**Consultation Response from KC,
Highways Development Management****2023/93559 27, Market Place, Huddersfield, HD1 2AD****Alterations to convert upper floors to 8 flats (Listed Building within a Conservation Area)****Date Responded: 09/05/2024****Responding Officer: CNB****Responding Ref: K5-7NW/39**

PROPOSED GROUND FLOOR

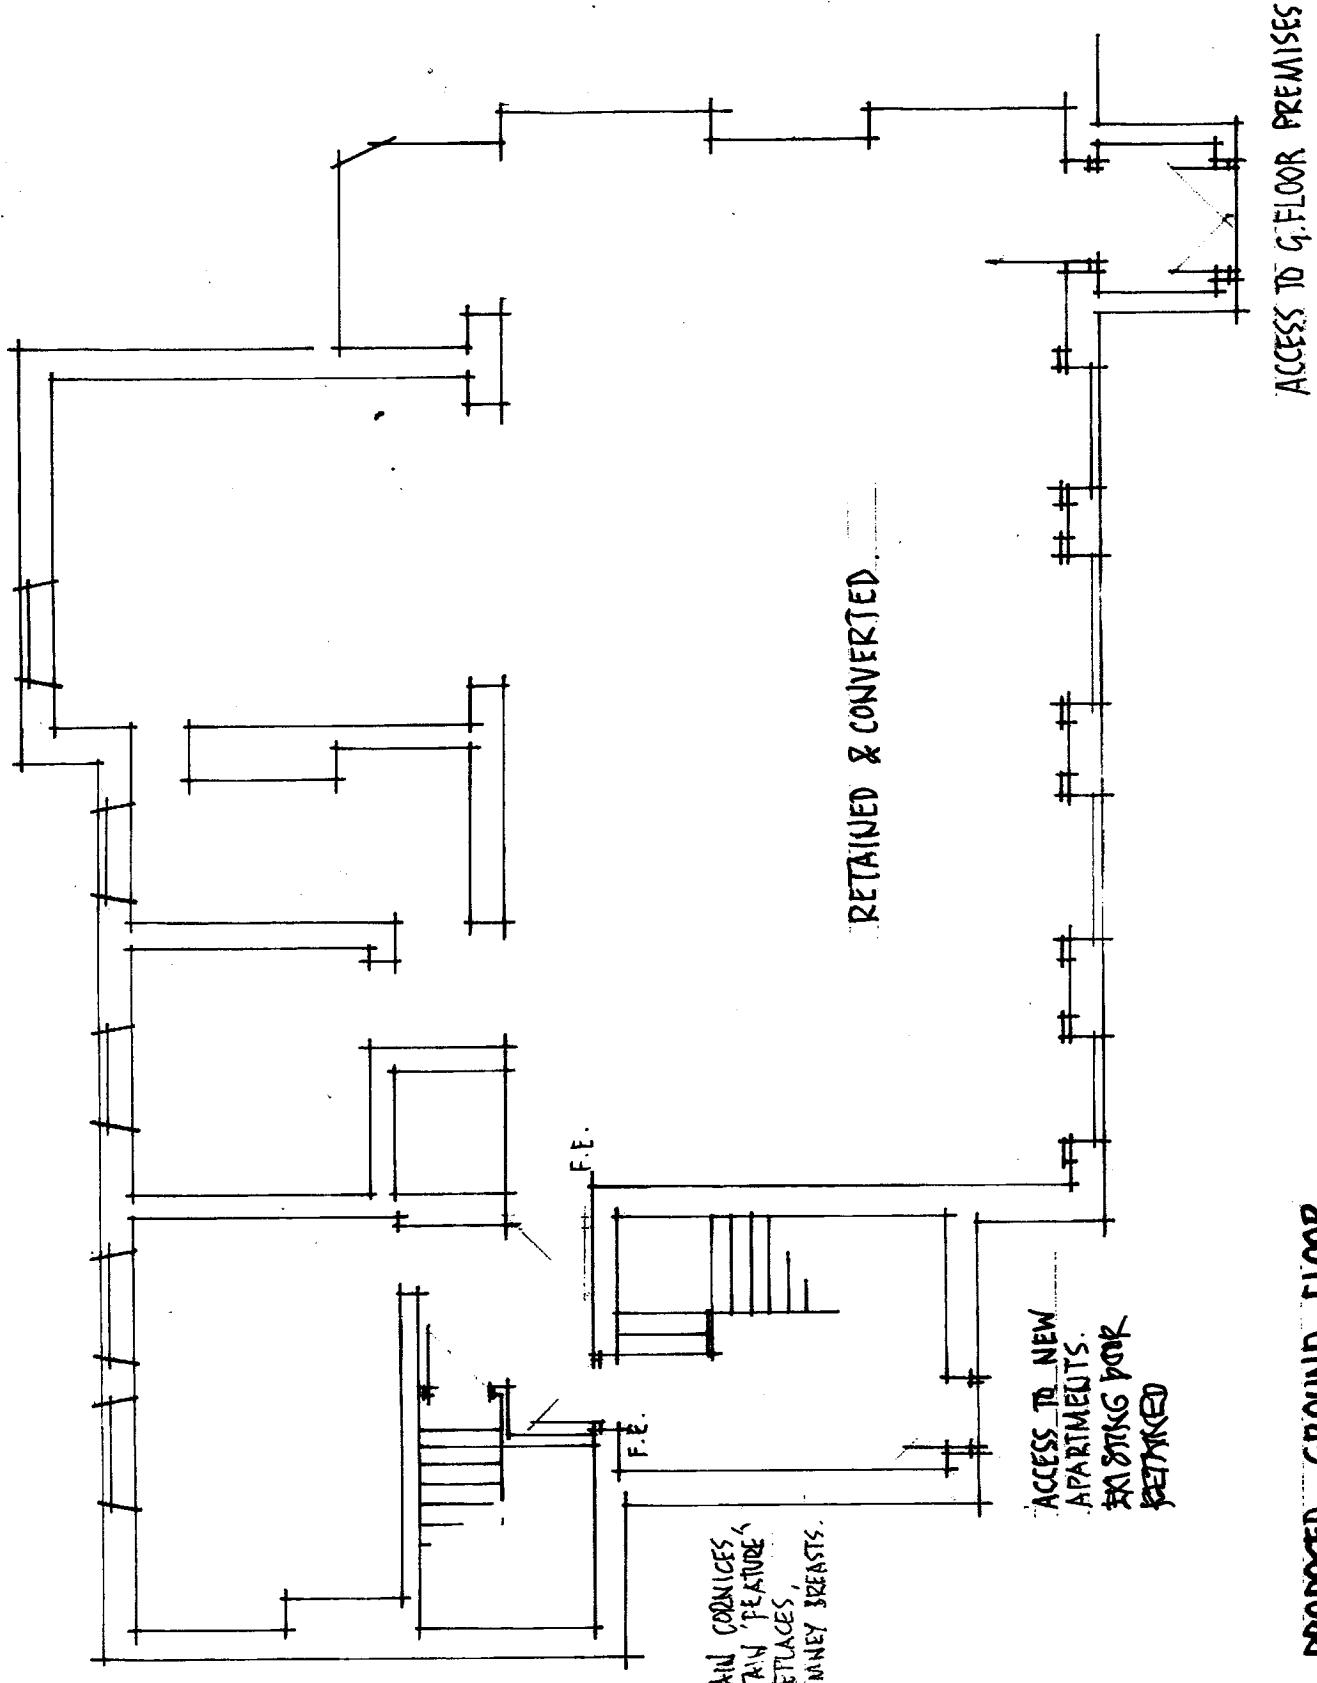
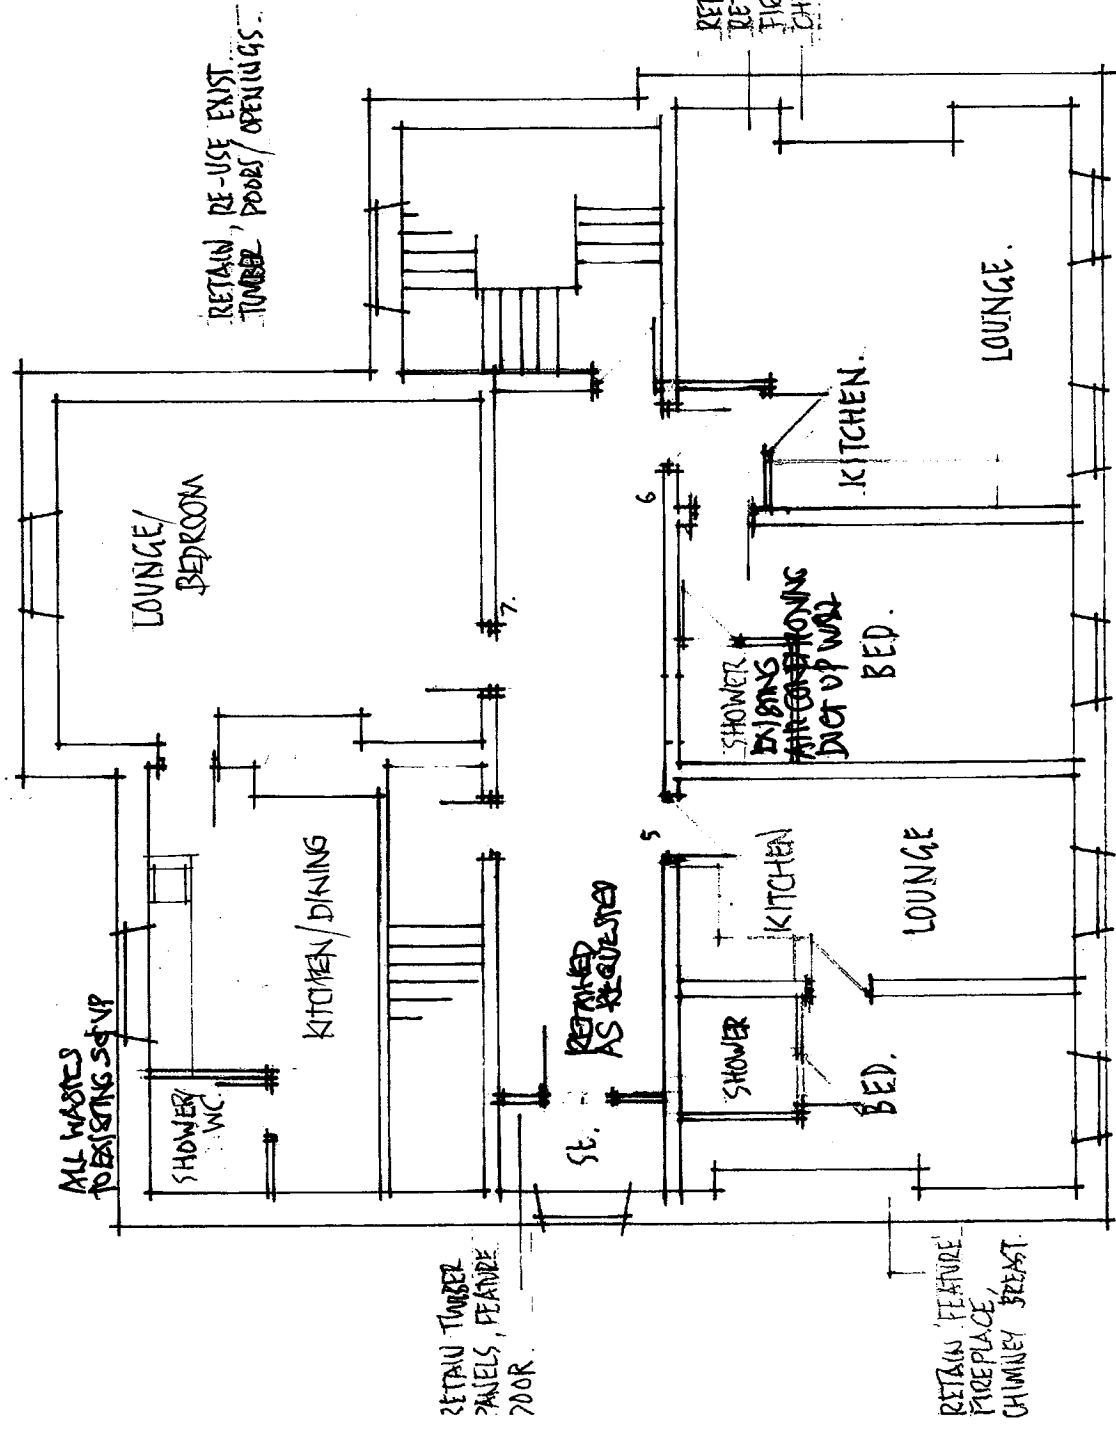
We would, however, require safe and secure cycle parking at the site, with 1 cycle space per dwelling unit (8 in total). Drawing “Block/Site Plan” indicates the location of a cycle store in a rear yard with an access on to Market Walk. We would need to see details of the cycle storage, which should be covered, safe and secure and this should be conditioned.

Drawing “Block/Site Plan” also indicates the location of the bin store, again no further details were provided, and we would recommend that these are provided, including the route from the flats to the bins that residents would need to take and any waste management arrangements, and that they follow guidance provided by Kirklees Waste Strategy team and can be obtained here;

A bin collection presentation point should be clearly indicated on a drawing, within guidance carry distances of the closest adopted highway that can accommodate a Kirklees refuse wagon, and this should be conditioned. It is noted that the passageway from the rear yard to Market Walk has a step at the market Walk end and this may not be suitable for larger “eurobins” if these are chosen. I have requested a consultation input and guidance from the Waste strategy team and will forward these details when they are available.

Before development commences, details of suitable cycle storage facilities shall be submitted to and approved in writing by the Local Planning Authority. The approved details shall be provided before

Before development commences, details of suitable storage, bin presentation points and access for collection of wastes from the dwellings hereby approved shall be submitted to and approved in writing by the Local Planning Authority. The approved details shall be provided before first occupation and shall be so retained thereafter.
